RE: Claremont Business Park Filing No. 1A, Lot 2, Private Detention/Stormwater Quality
Pond - Asbuilt Certification
EPC Project # PPR-192

ASBUILT - DRAINAGE MAP

SAND FILTER BASIN AND SPILLWAY DETAIL (NOT TO SCALE)

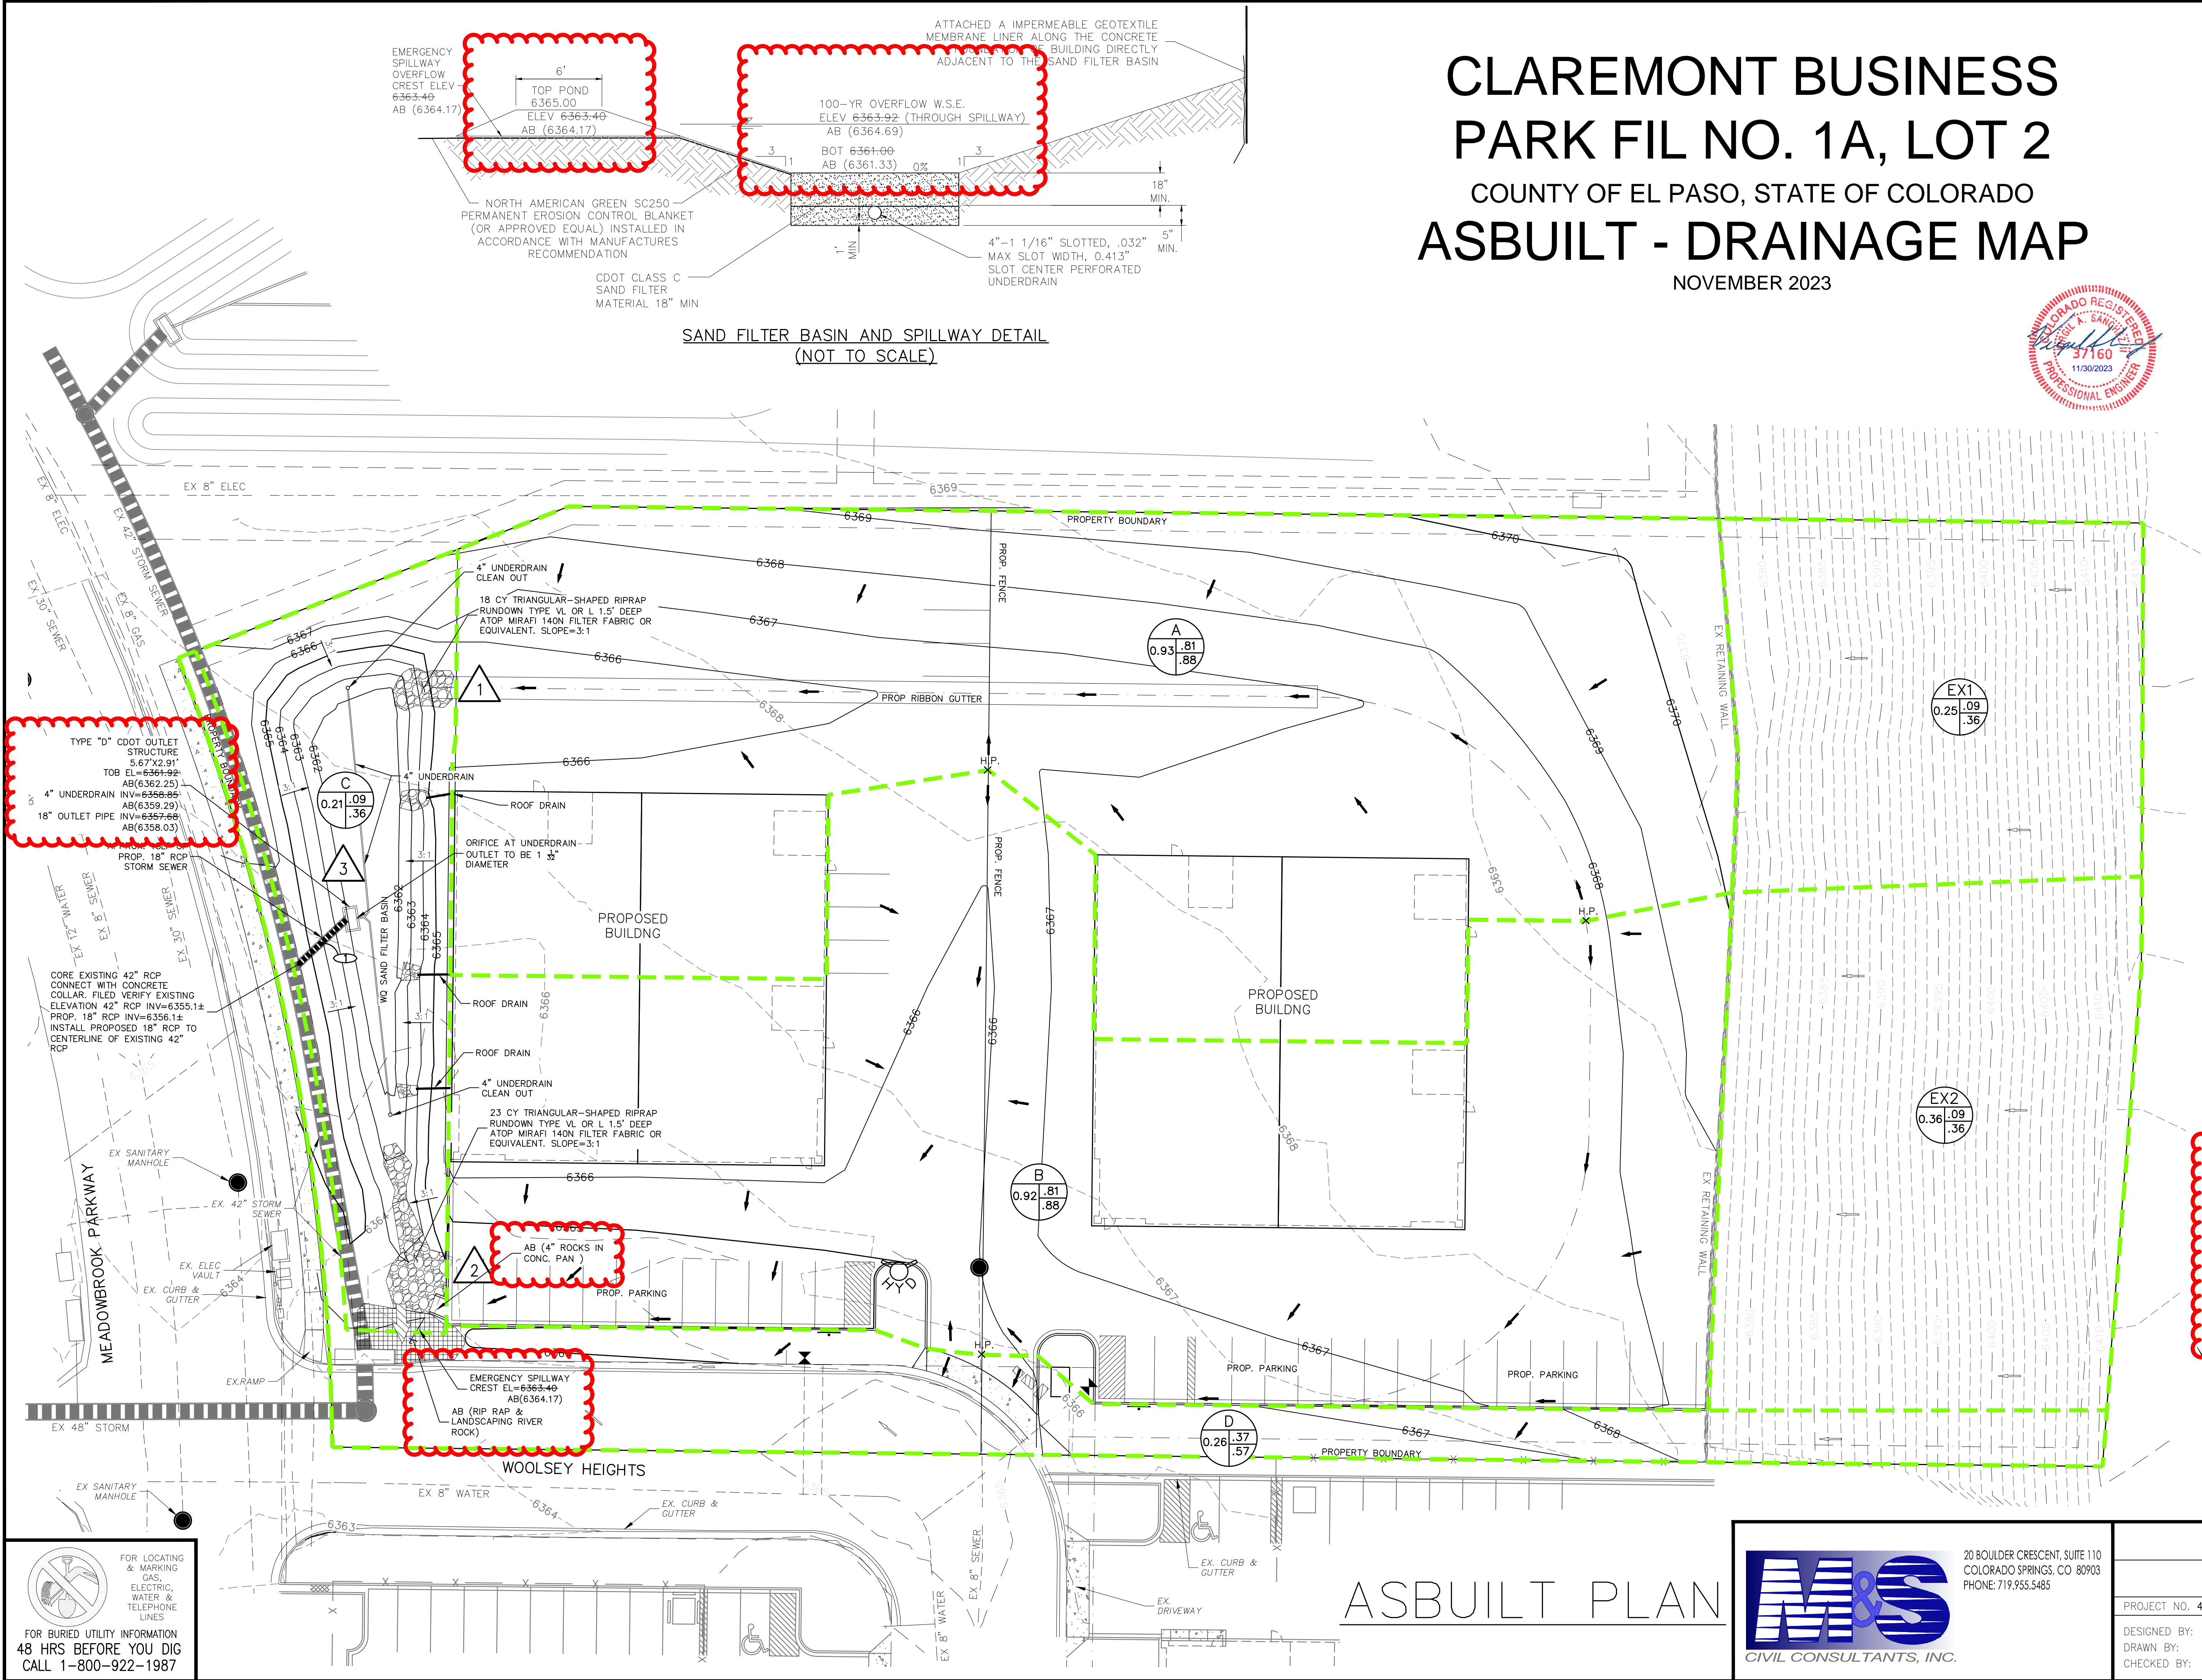
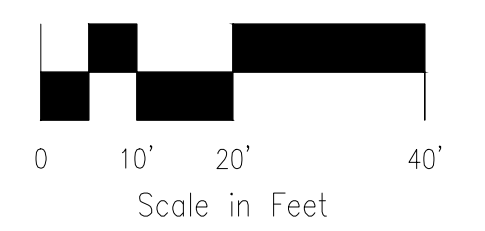
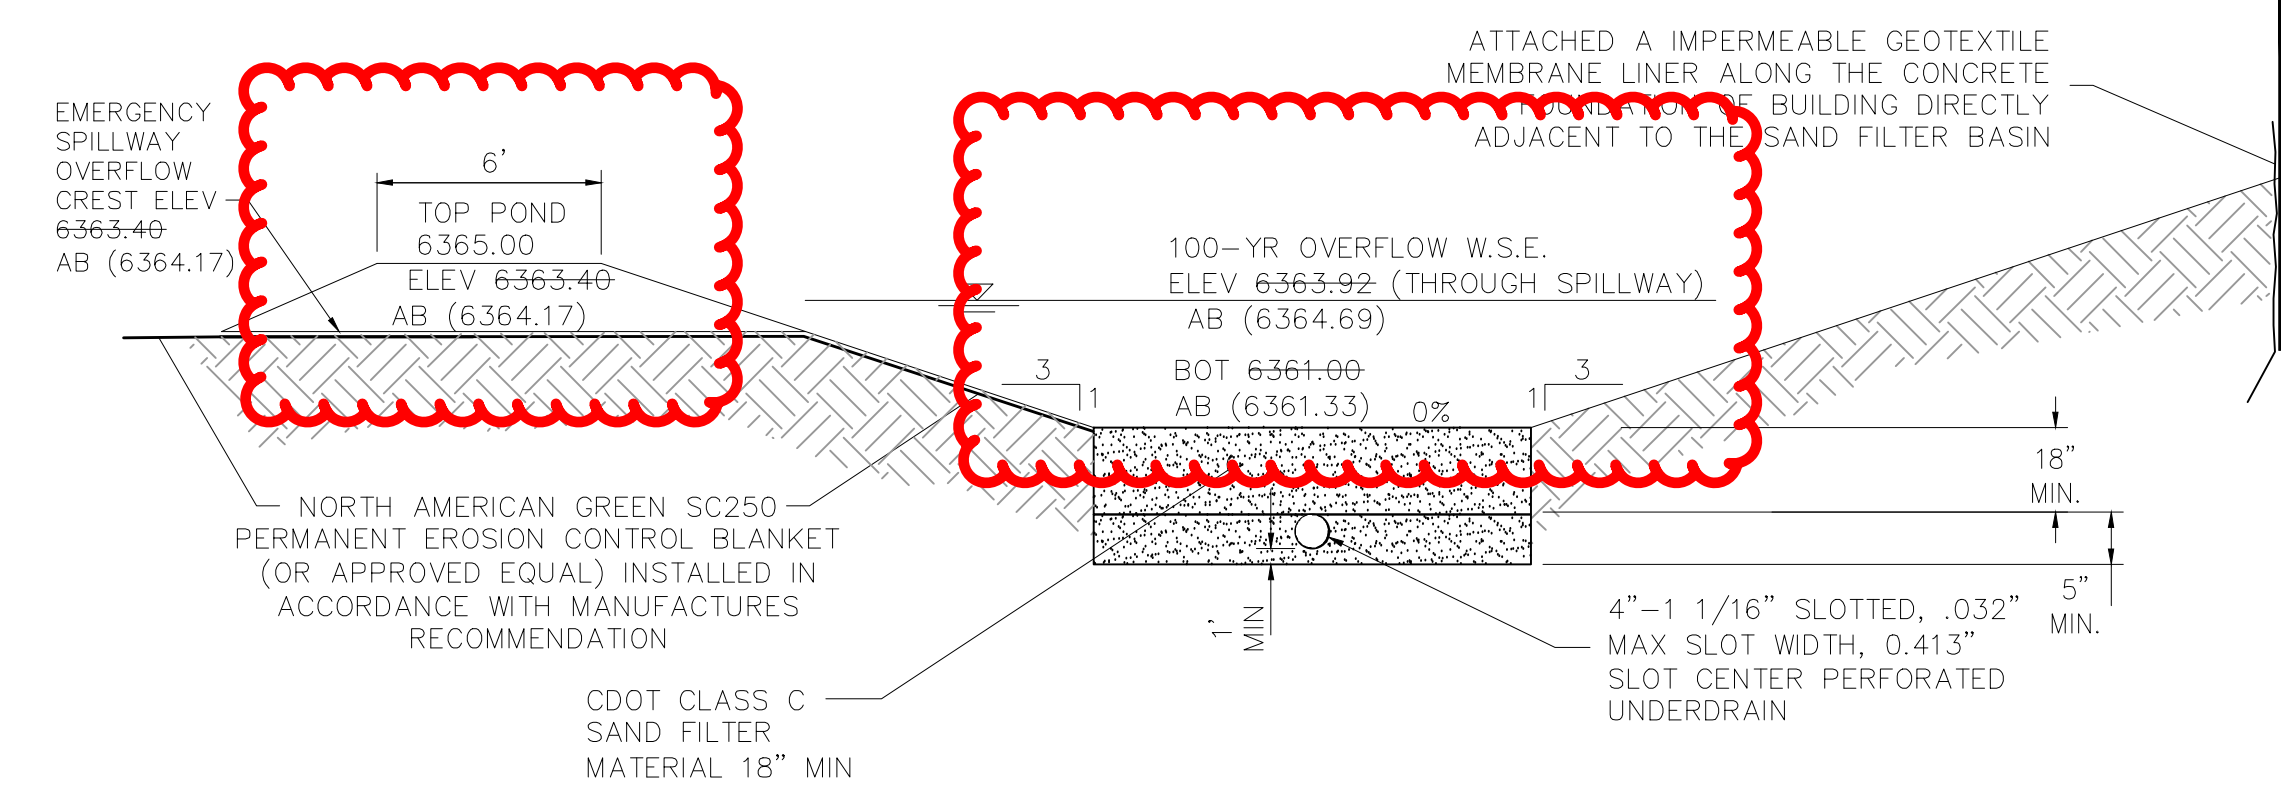
Install spillway per original plan (ECB and seeding) or submit calculations that show that the installed landscape rock can withstand velocities of overflow events.

Detention Basin Outlet Structure Design

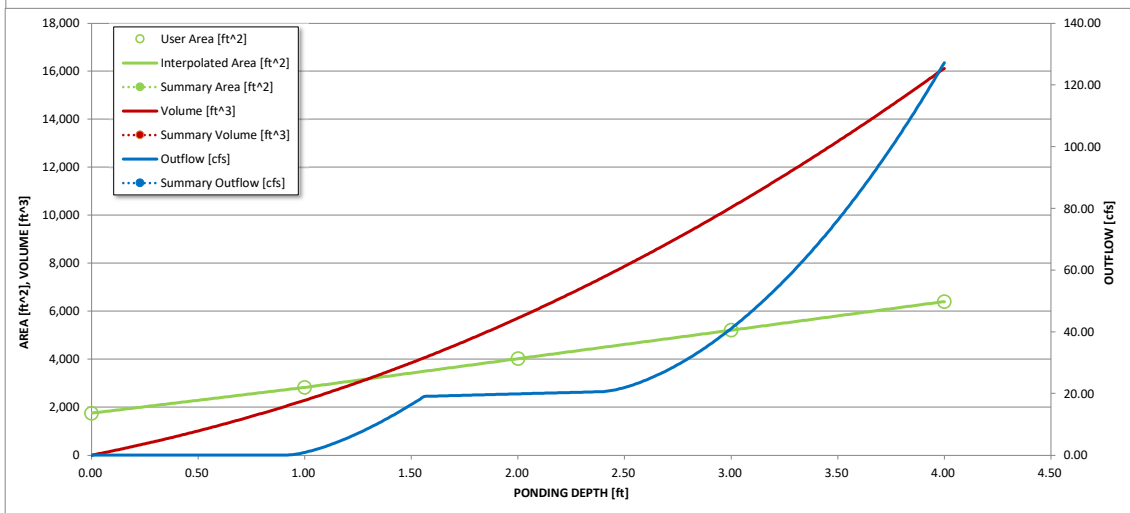
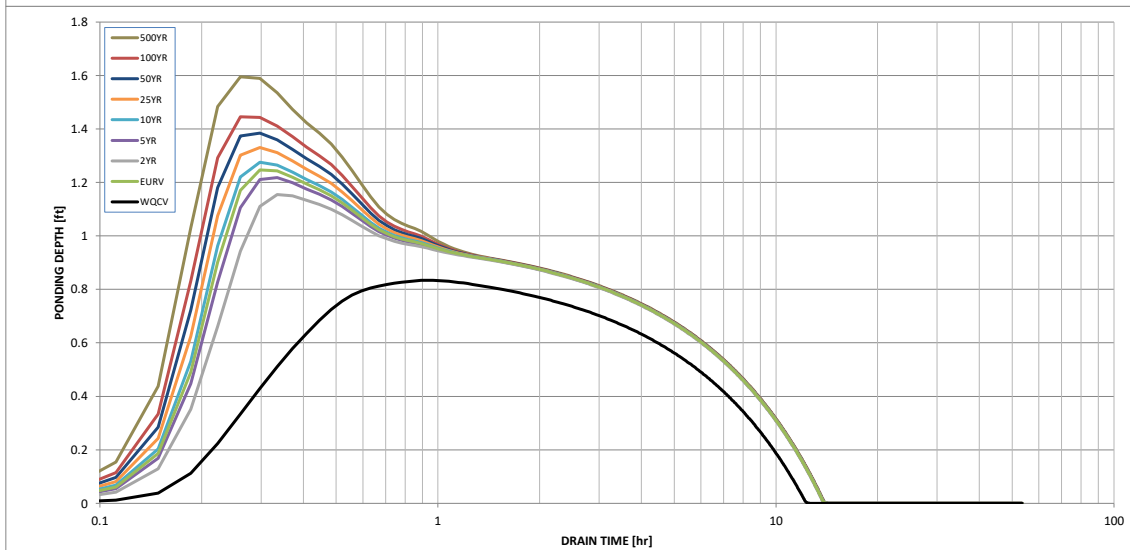
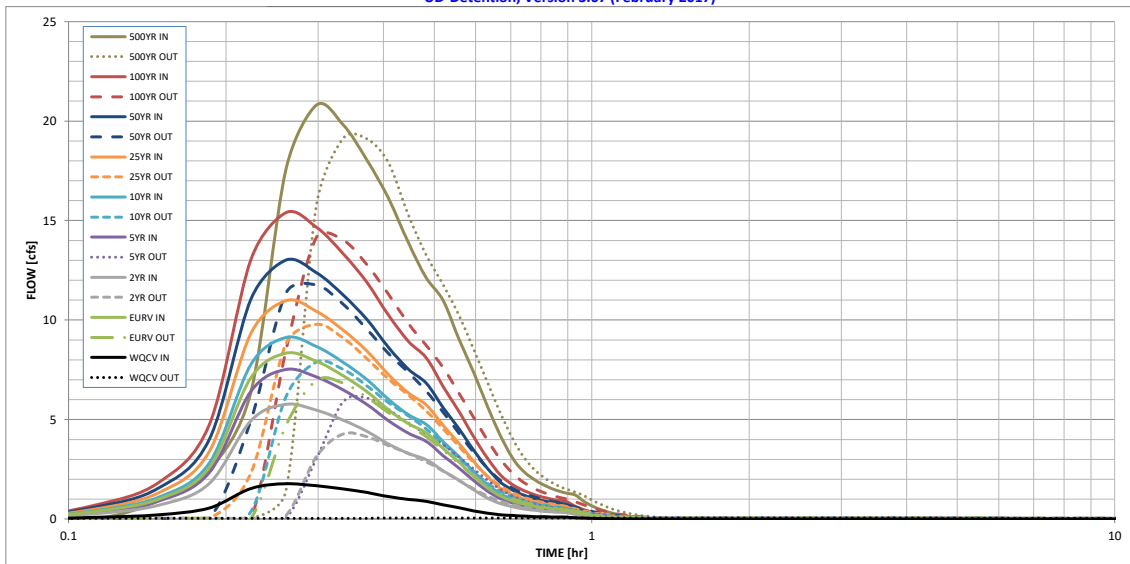
Please highlight the cells below that were changed from the original FDR to these as-builts. I highlighted in orange the two cells that I noticed have changed.

Was 3.32 in the original FDR. The as-builts show that the invert was actually installed 0.35ft higher than the original design. So it's unclear why this value was actually instead lowered by 0.88ft on this sheet.
